Comments from Sibford Ferris Parish Council on Gade Homes Design Access Statement (DAS): Ref: 21/02893/REM

### SCALE, HEIGHT AND MASSING

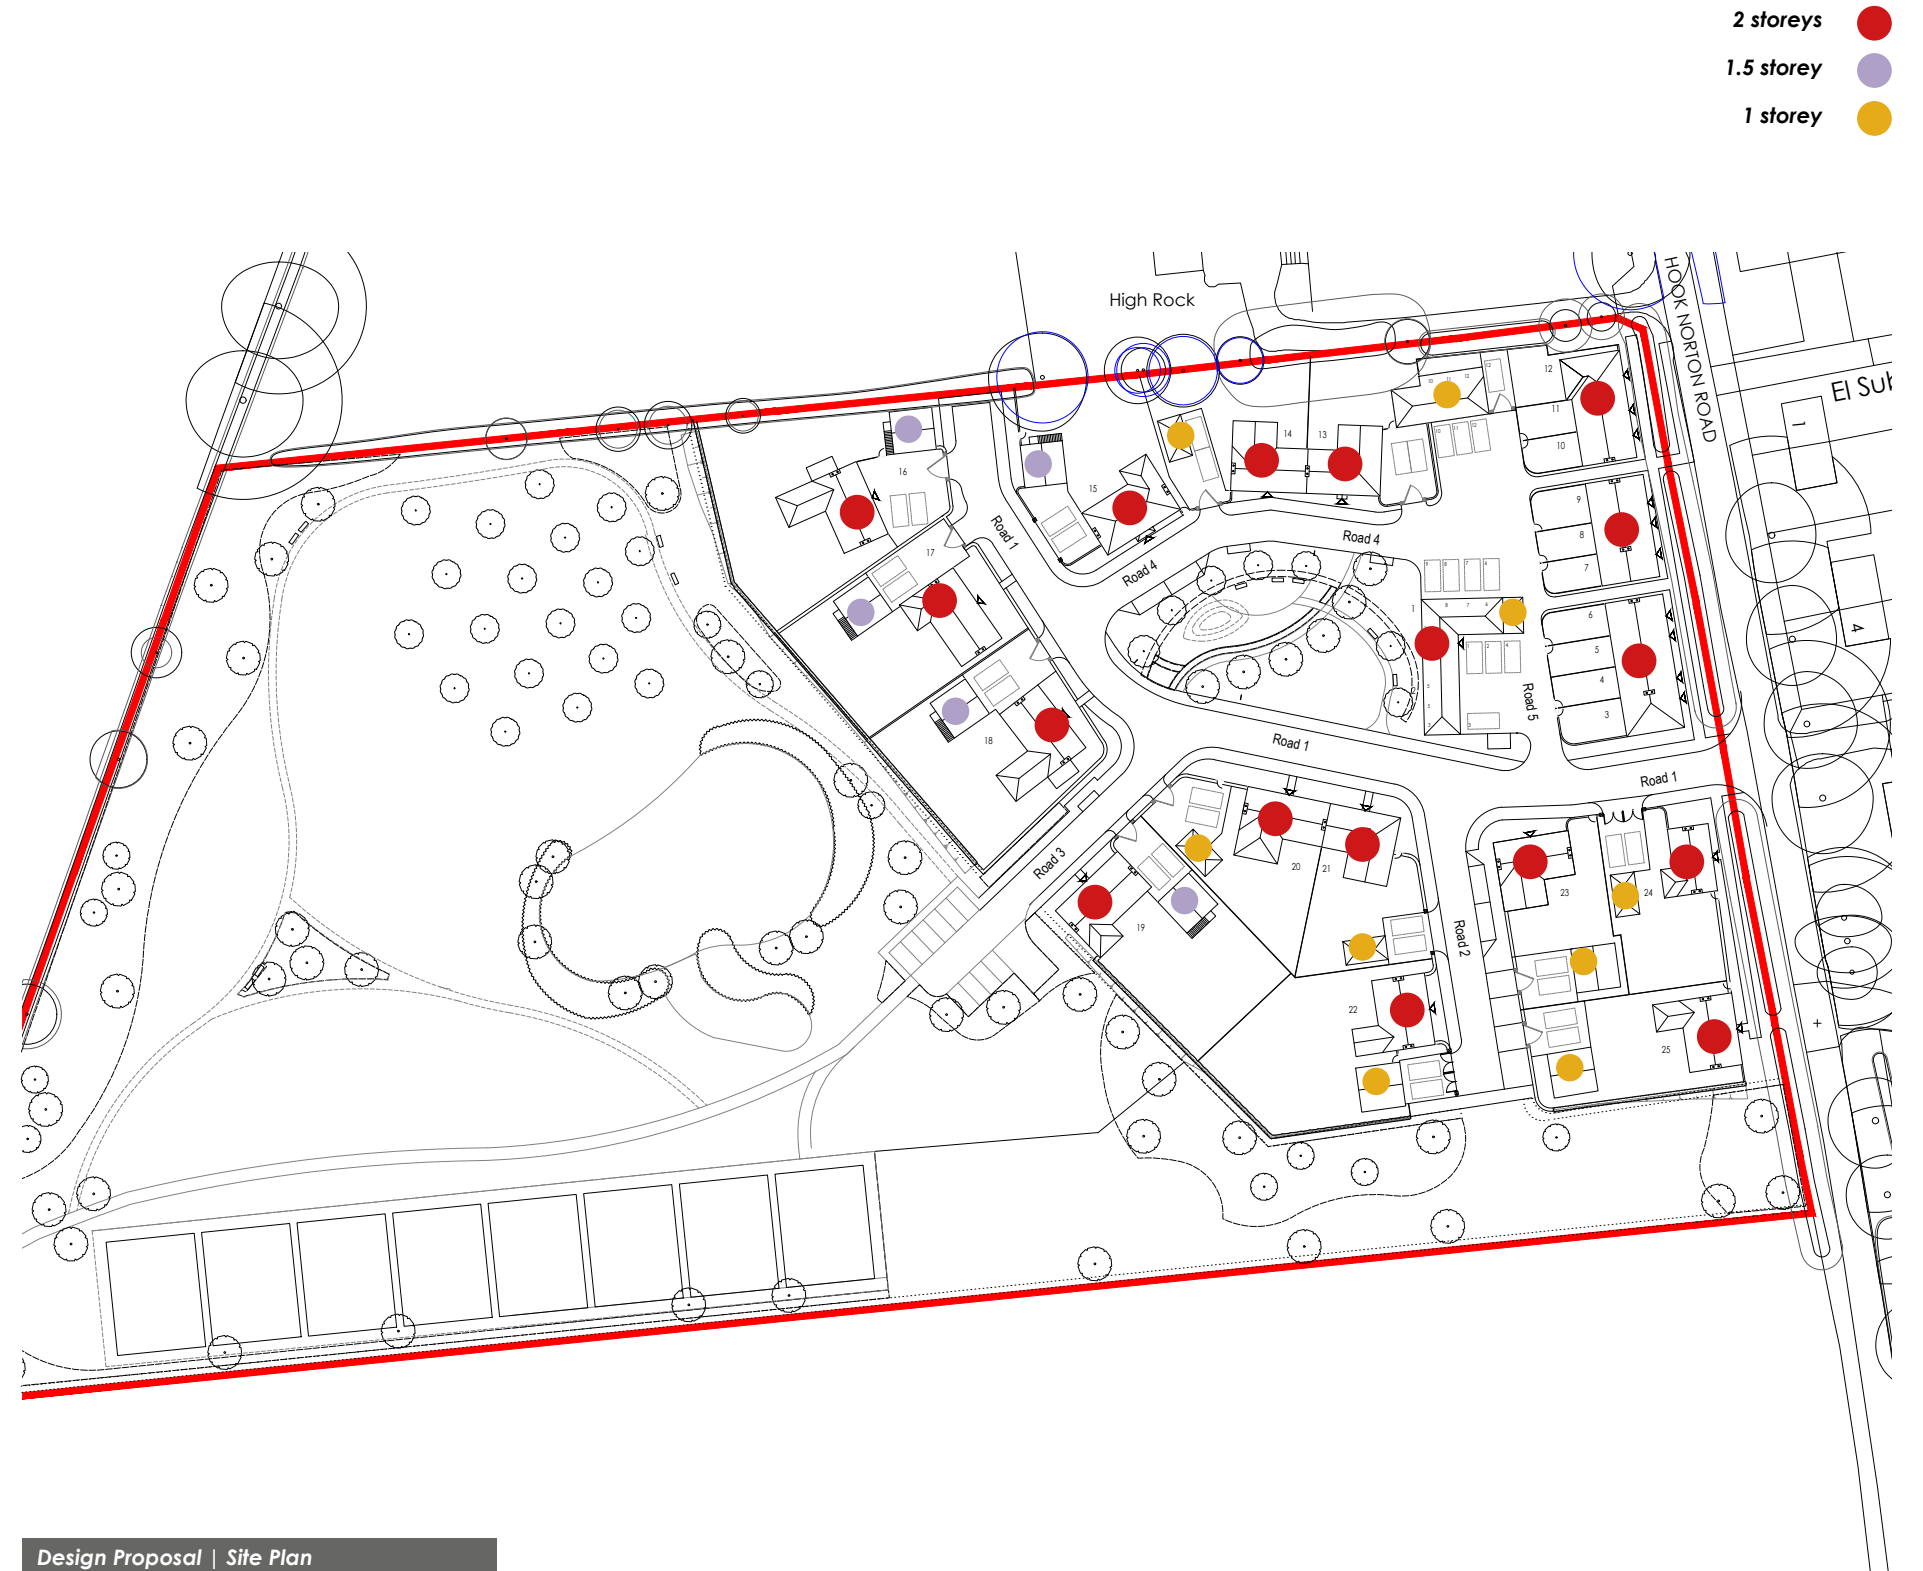
2. Our expectation is that Cherwell District Council (CDC) will undertake comprehensive due diligence checking all aspects of the Gade Homes DAS to ensure consistency and compliance with CDC planning policy, regulations and the approved outline planning permission. This to include designed scale, height and massing.-Relevant DAS sections below:

4.37 The proposed dwellings are 2 storeys, reflecting the scale, height and built form within the immediate context and the wider village context.

4.38 The proposed heights of houses vary between 7.3m and 9.7m. 4.39 Roof pitches are consistent and as prescribed in 1Cherwell Design SPD (2018) at least 40 degrees to the horizontal with the ridge-line generally running parallel to the principle elevation.

### DRAINAGE

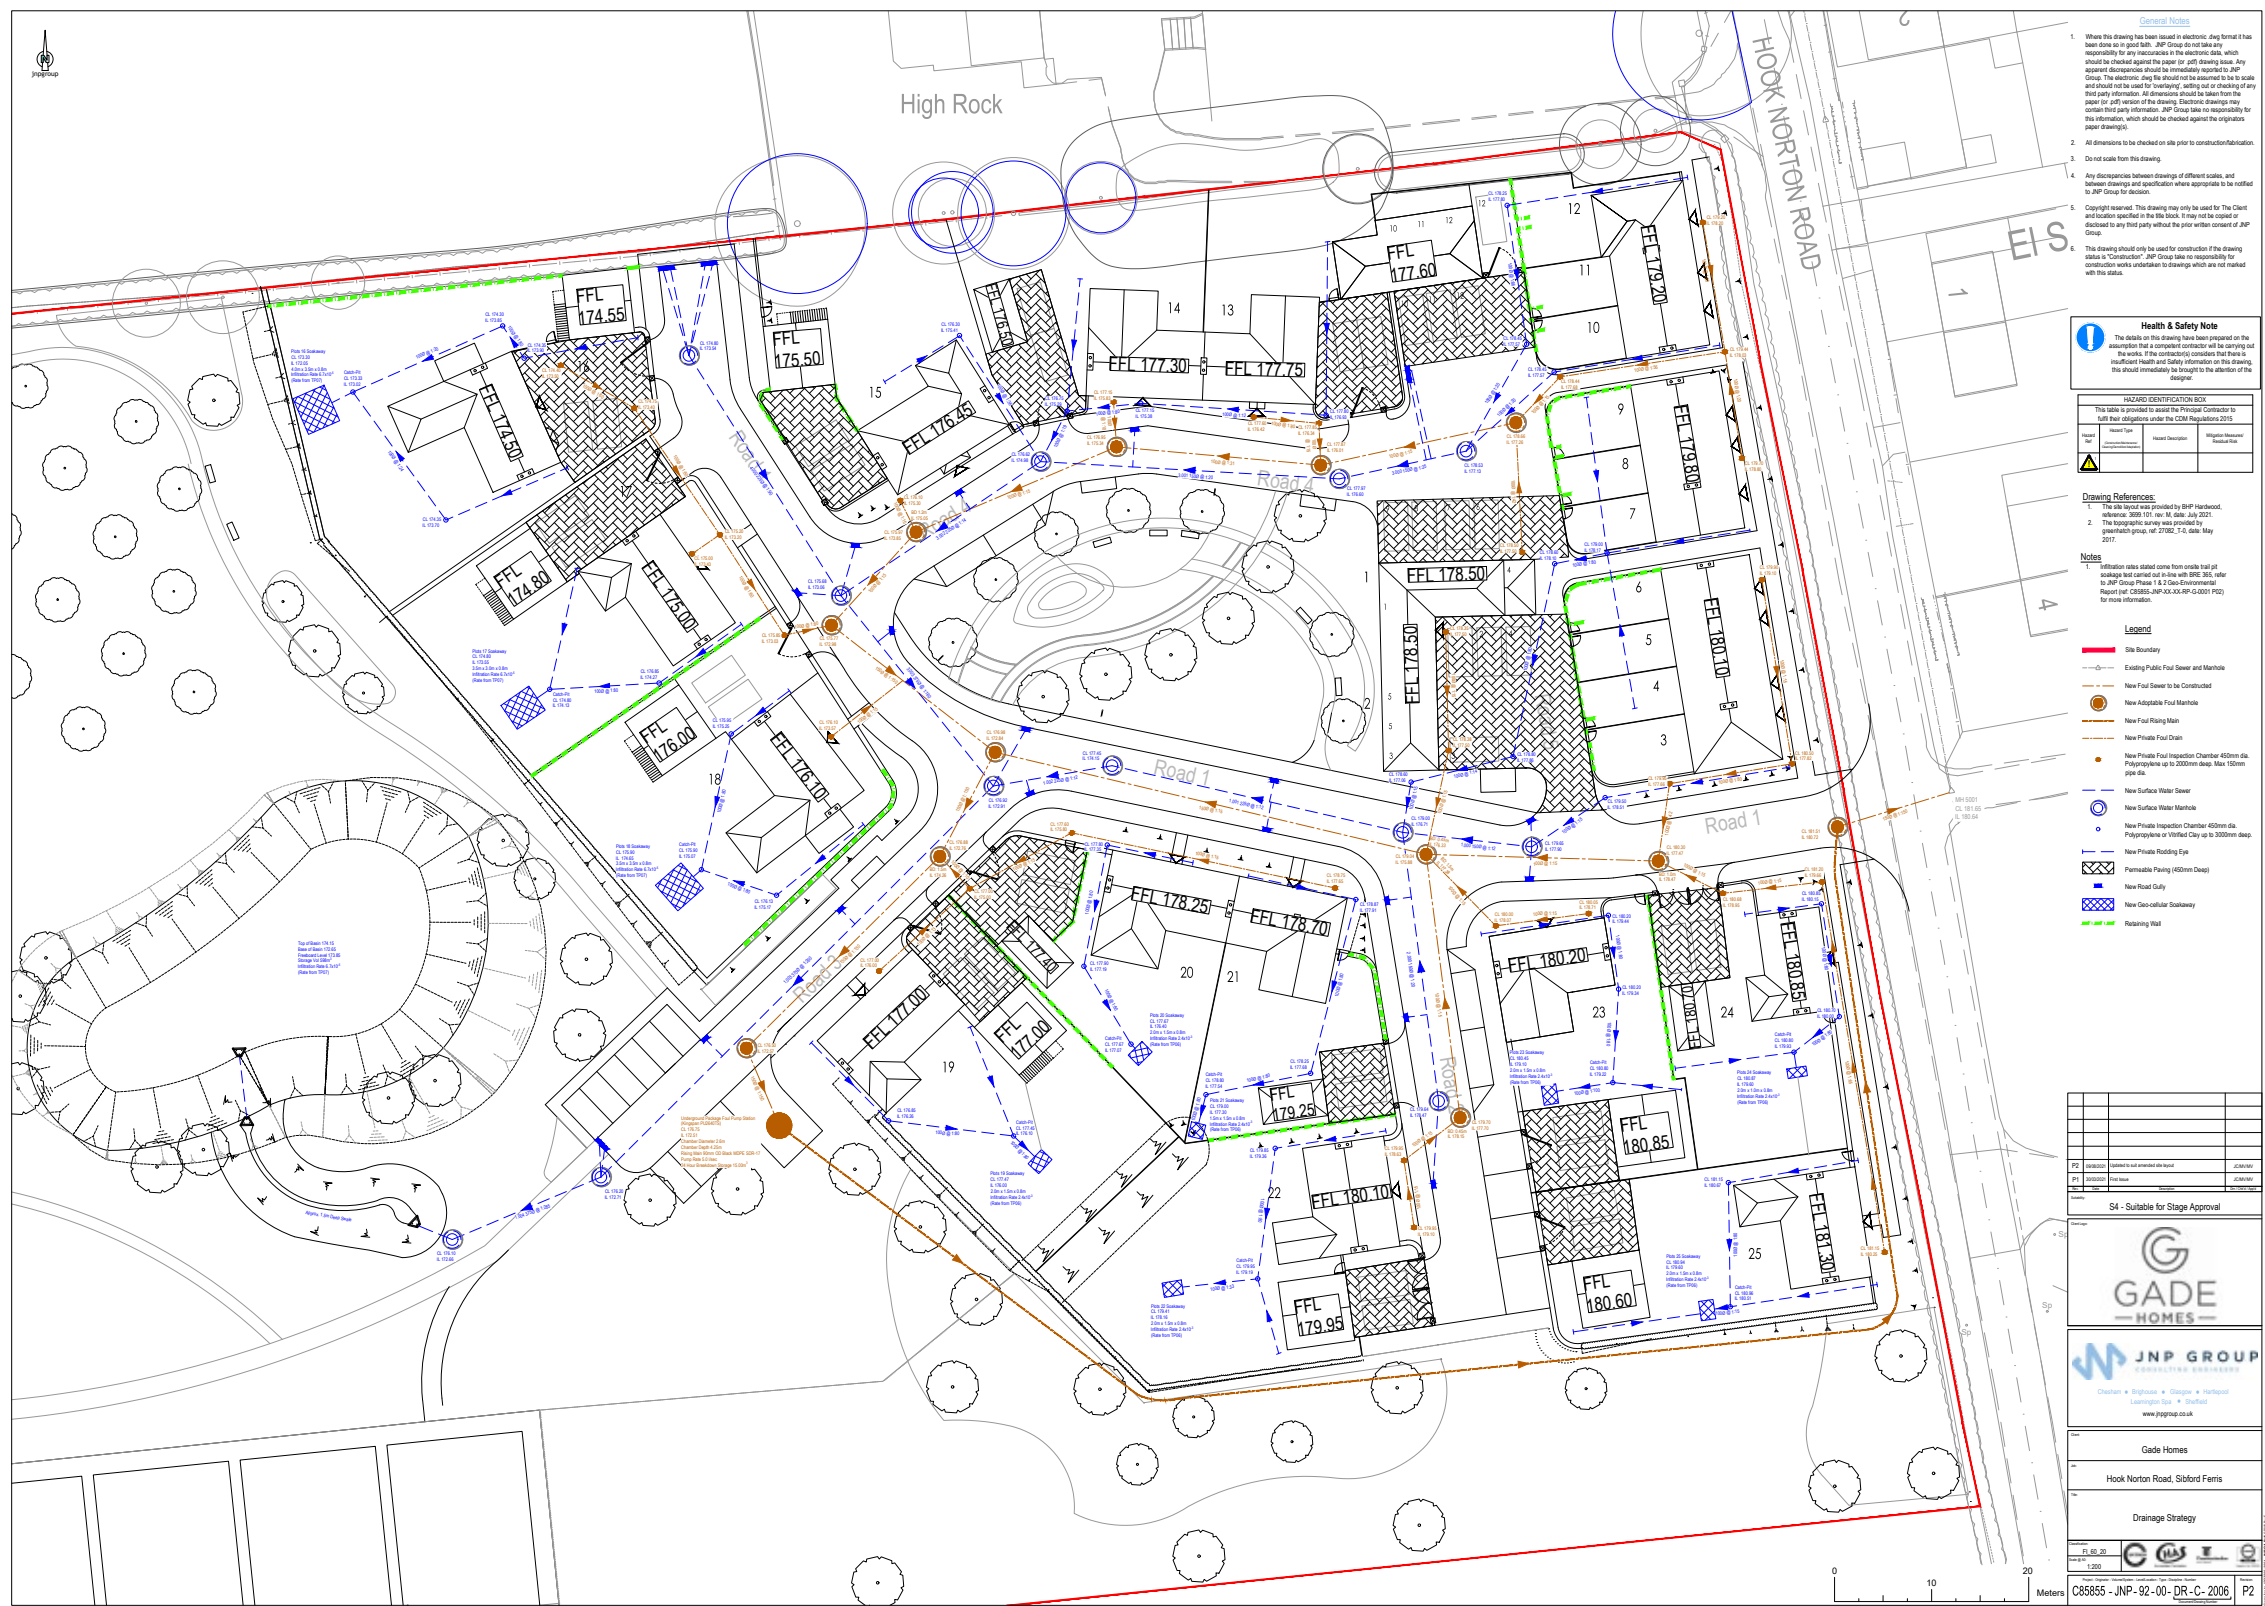
1. The Parish Council still have concerns over untested infrastructure impact, specifically: sewage, water and power supply. Relevant DAS sections and Infrastructure response below. Sewerage capacity / capability is a **major concern**:

5.3 Foul water will be discharged into the existing Severn Trent Water network in Hook Norton Road. Due to the shallow nature of the existing foul sewer a connection by gravity is not achievable, therefore a below ground packaged pump station is proposed, as shown on the JNP Group drainage strategy drawing shown overleaf.

The following response has been received from Severn Trent in relation to the Sewerage Capacity. This identifies critical activity that needs to be taken to determine capacity and avoidance of future issues.:

With reference to the above planning application the Company's observations regarding sewerage are as follows. Foul is proposed to discharge into the public combined water sewer. As a pumped solution is being proposed for foul for this site a sewer modelling assessment will be required, this is to determine what impact the generated flows from this site will have on the network and to determine the maximum pump rate that could be accommodated within the existing network without worsening the existing sewer performance in rainfall events. Severn Trent may need to undertake a more comprehensive study of the catchment to determine if capital improvements are required. If Severn Trent needs to undertake capital improvements, a reasonable amount of time will need to be determined to allow these works to be completed before any additional flows are connected.
